ENG-PUDSP21006-R1-PDR.pdf Markup Summary

PRELIMINARY DRAINAGE PLAN
PUDSP 21-00X

THE RIDGE AT LORSON RANCH
MARCH, 2021

MAP POCKET

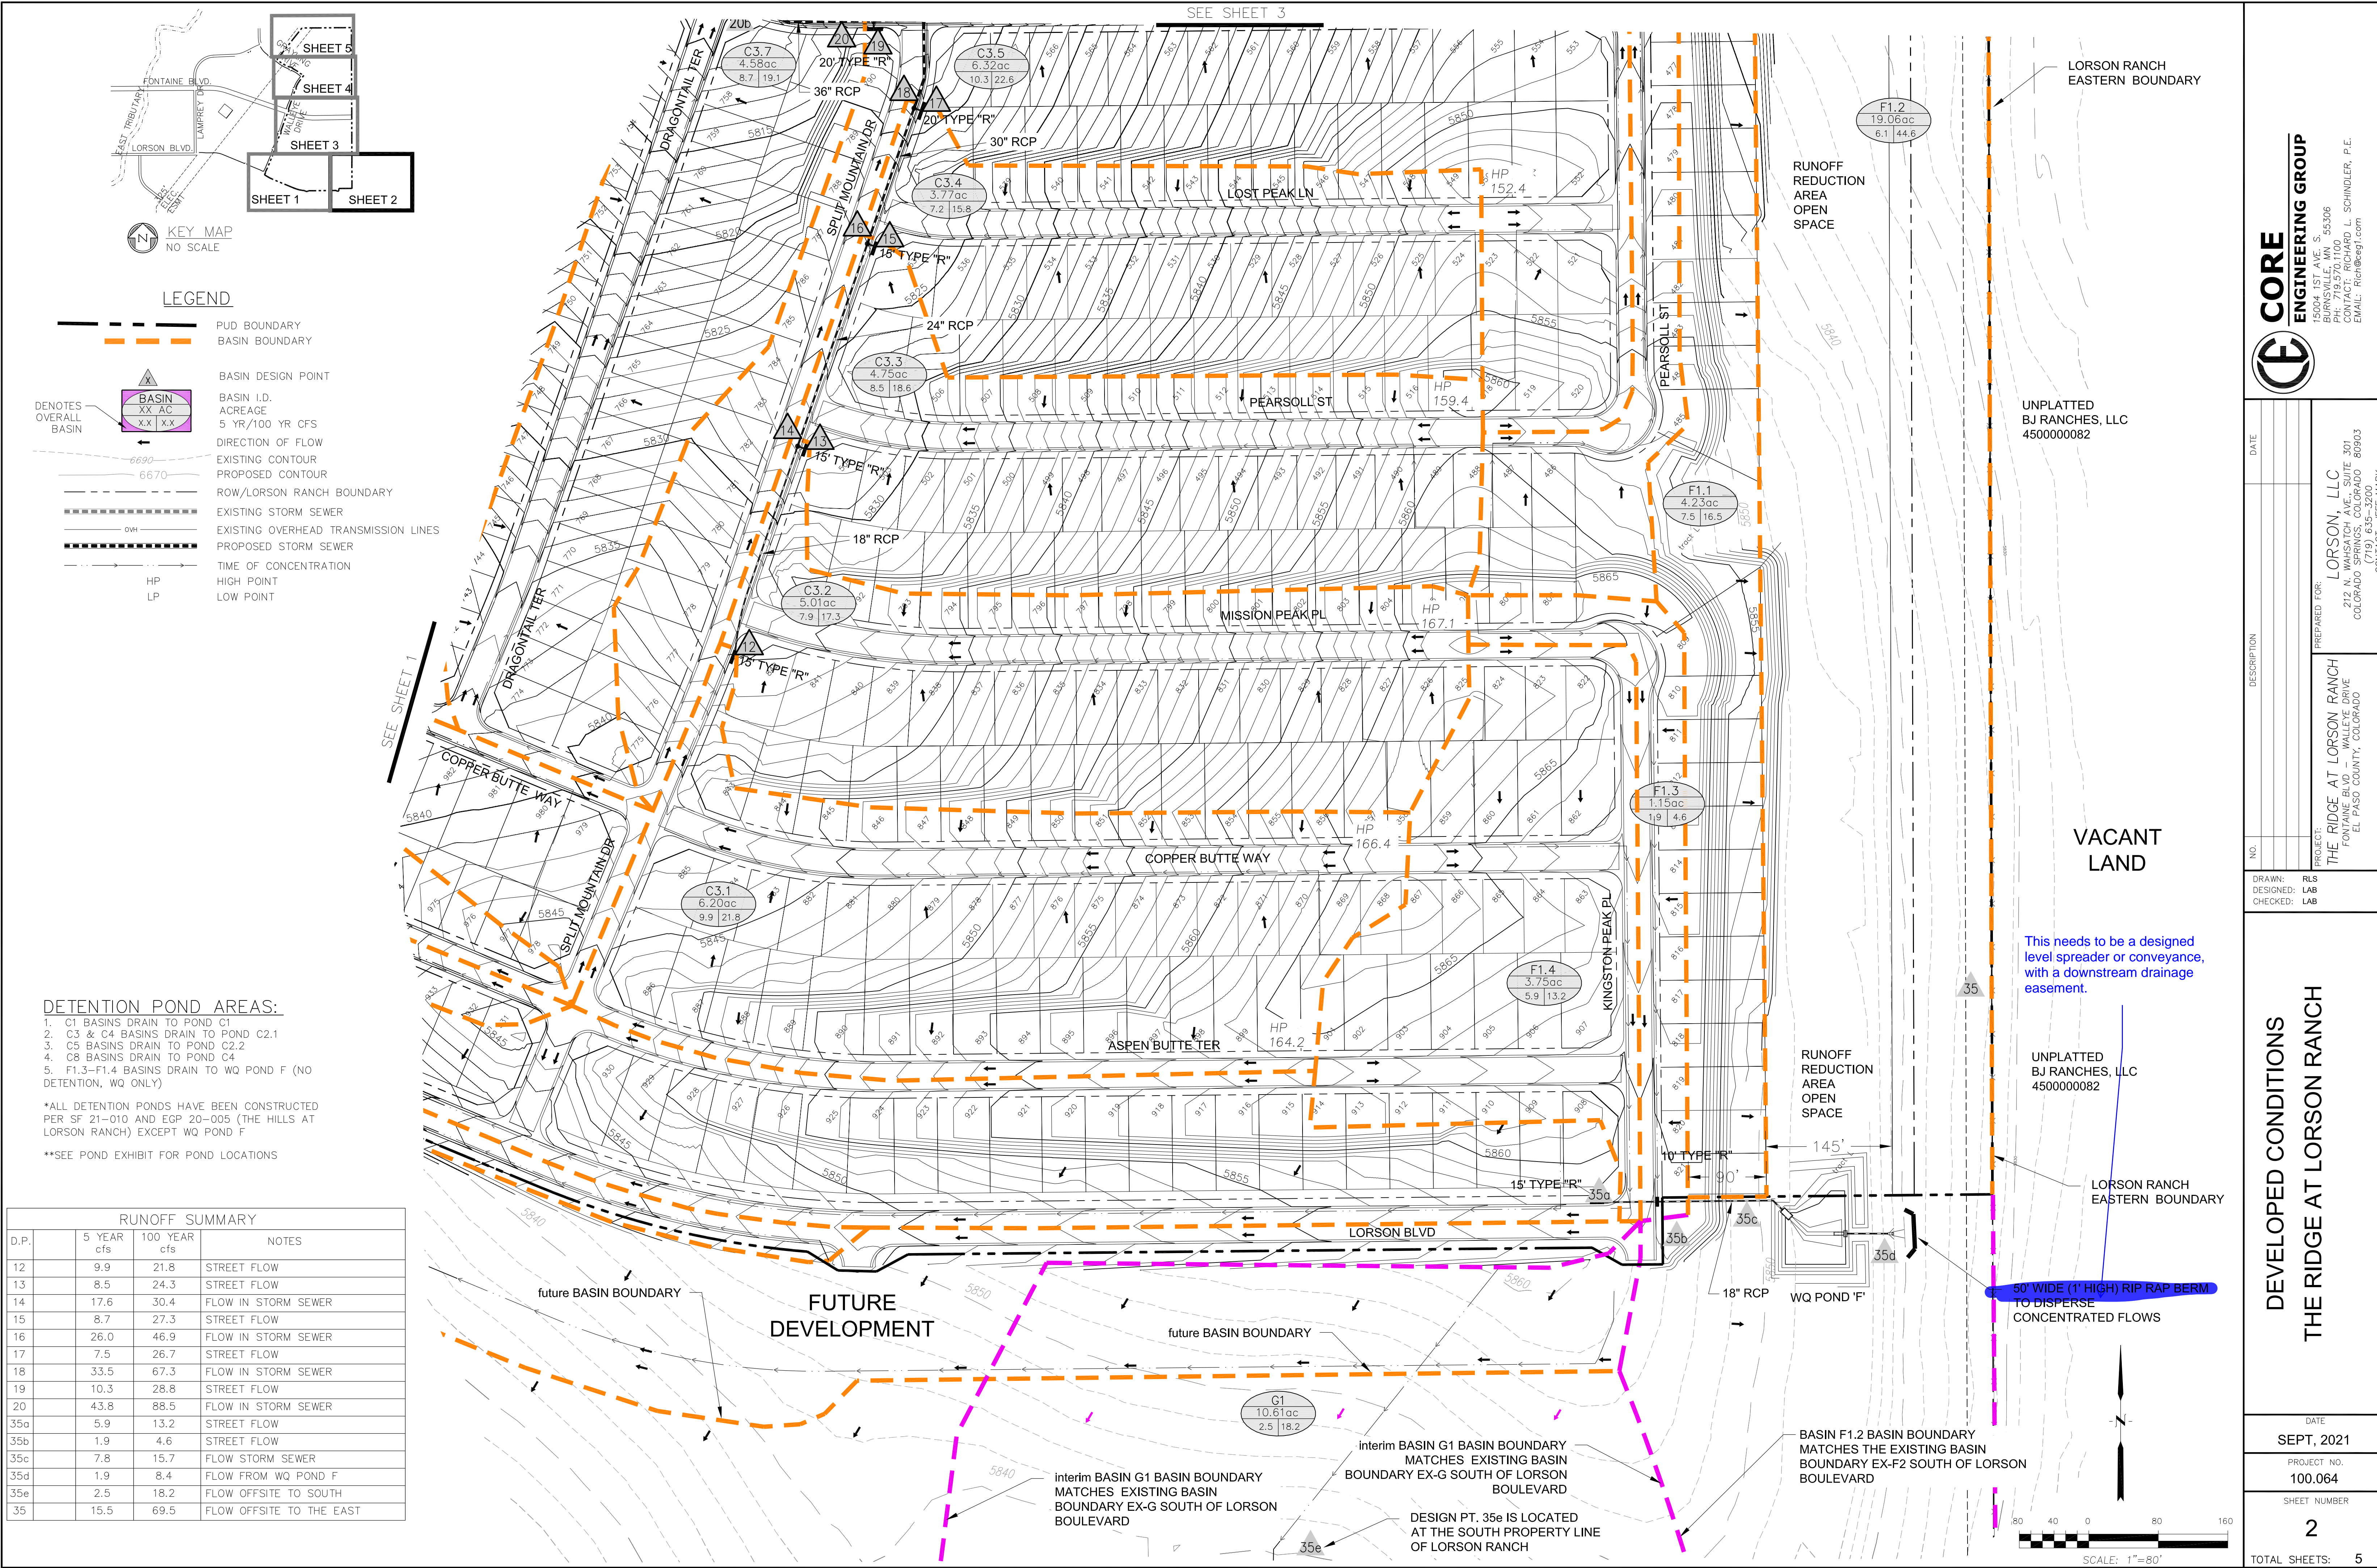
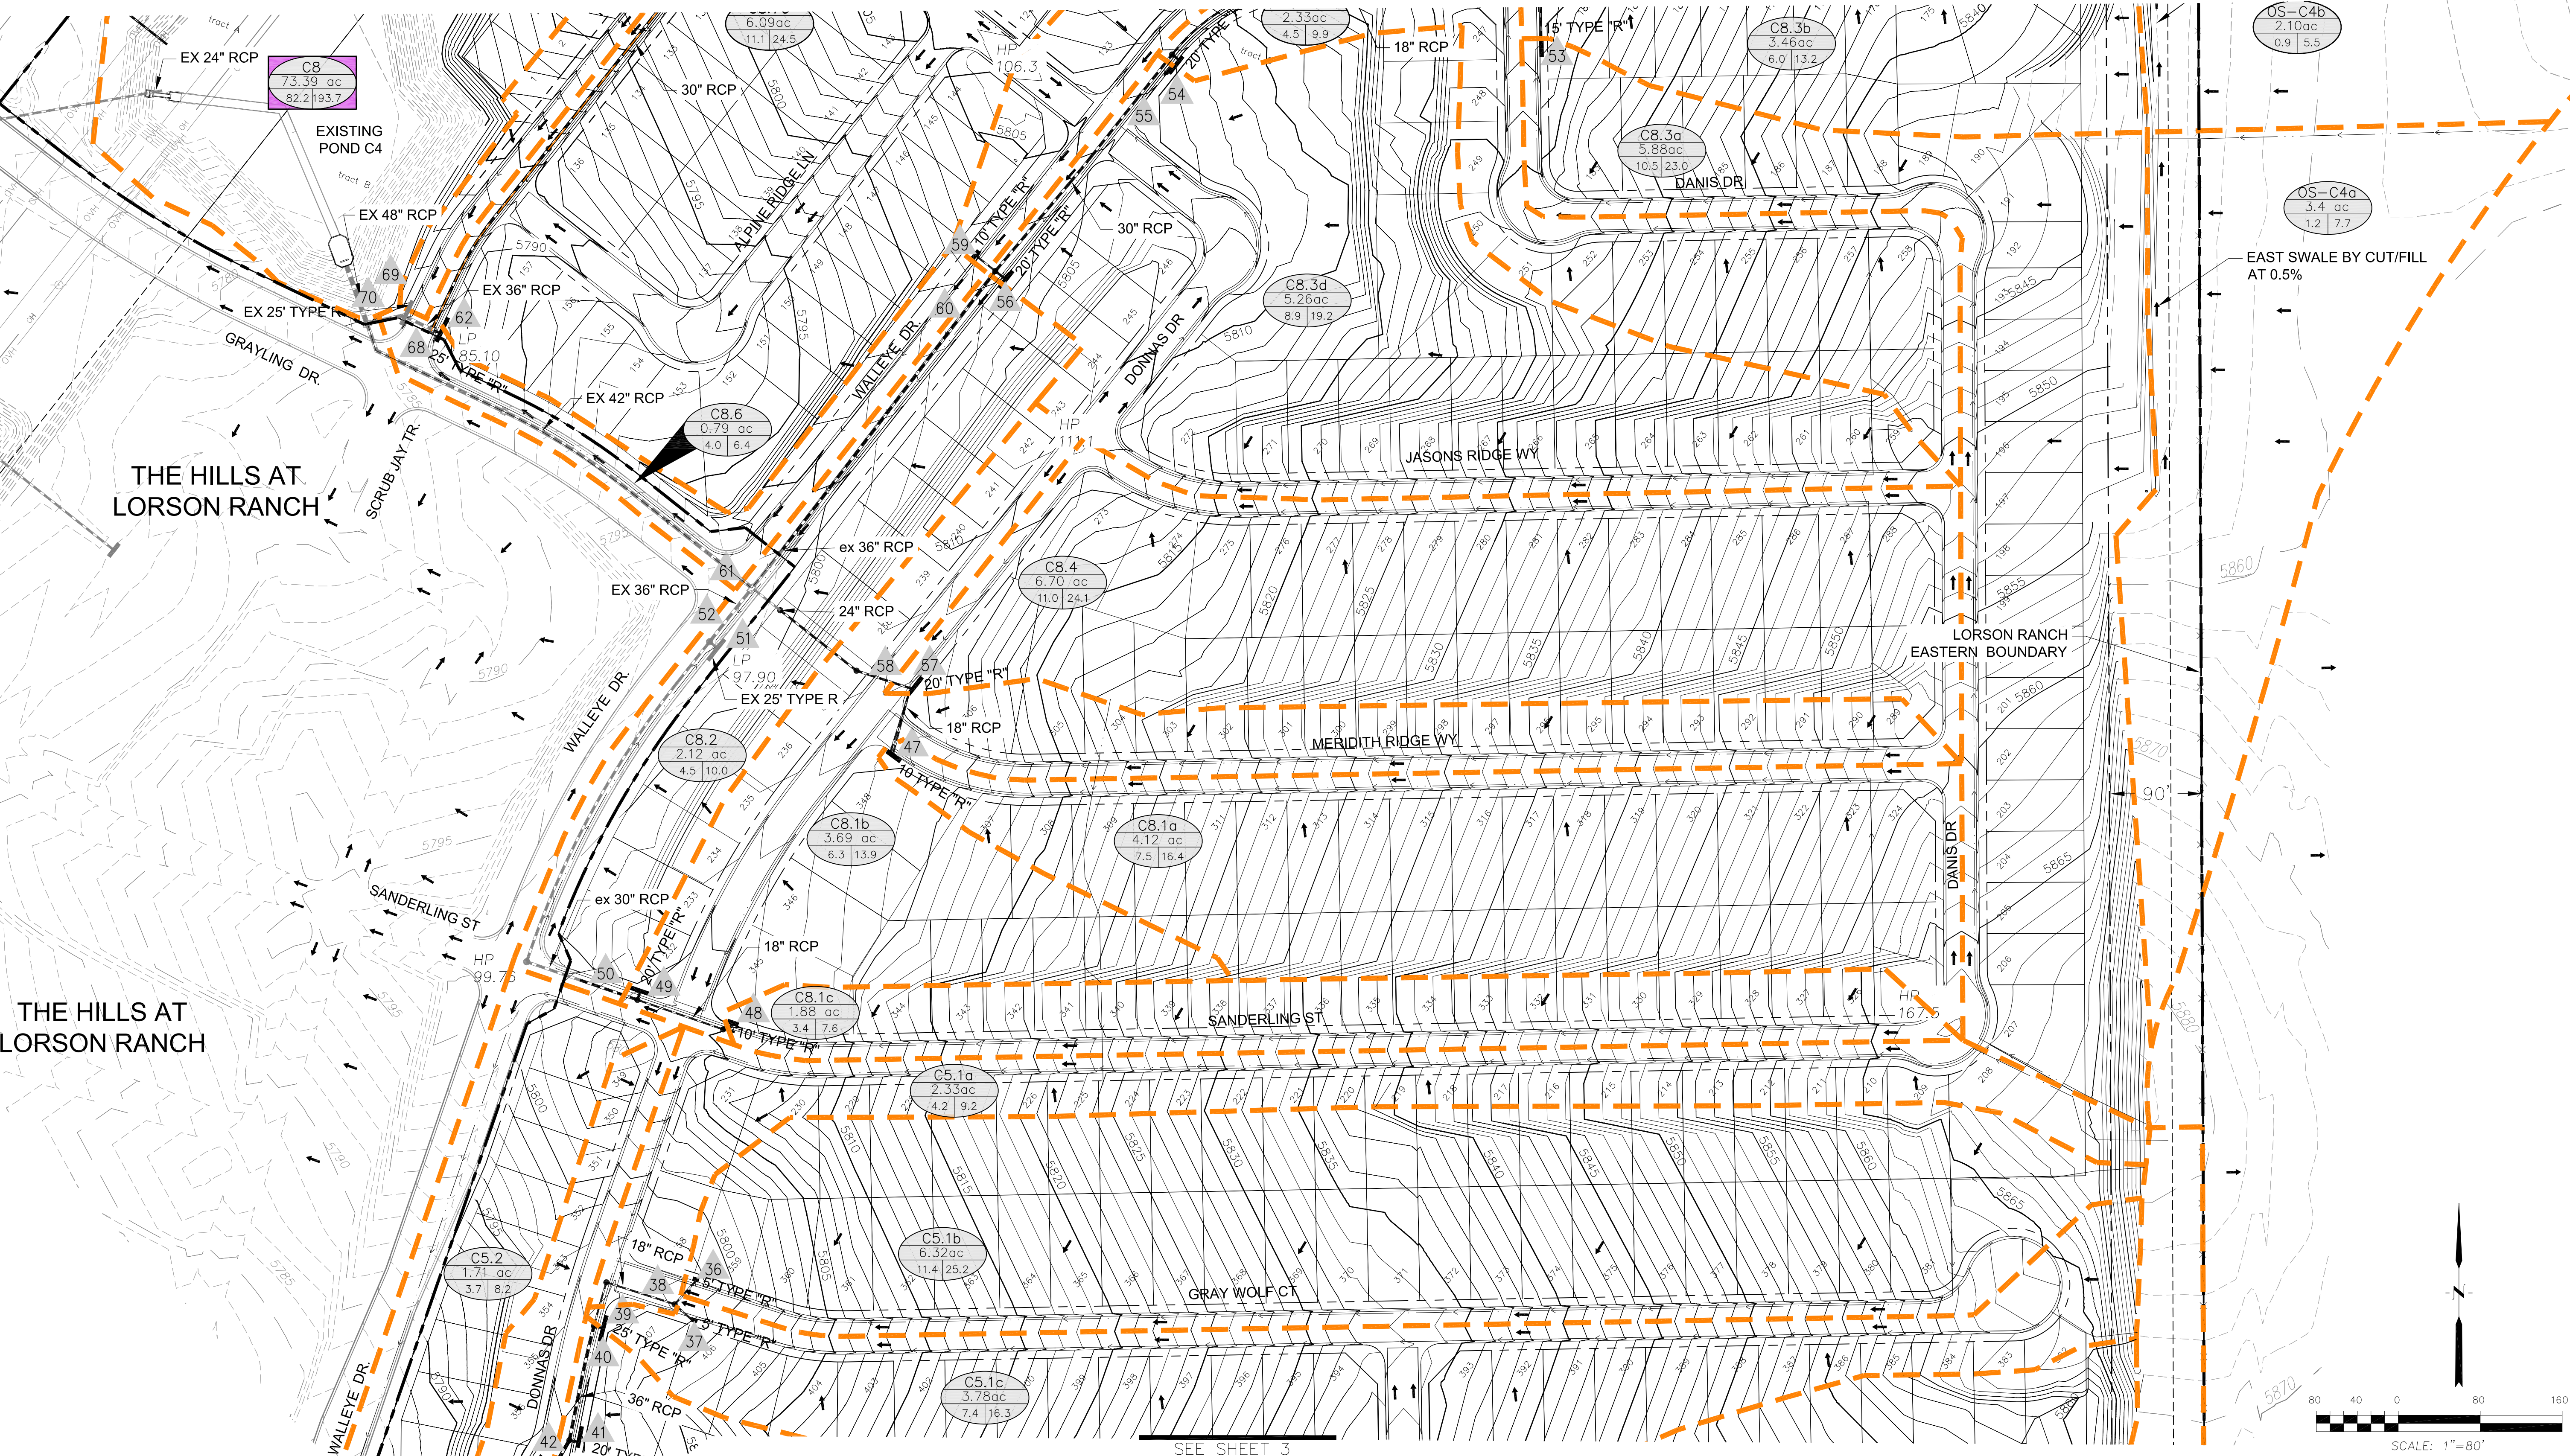
Show and label linetype for areas tributary to each pond as shown on Page 143, typical for all 4 plan sheets.

Label inlet

show existing curb and gutter

If inlet could overtop with flows >100-yr storm, consider providing a berm or wide swale to ensure that flows don't enter Lot 357.

What is the flow from this area and is a larger swale needed between lots?

Where would approximate low point be for Meridian Road and what would future flow be?

is a conveyance needed to keep flows out of Lot 158?

~ 8 Ac?

Should this have the purple border for overall basin?
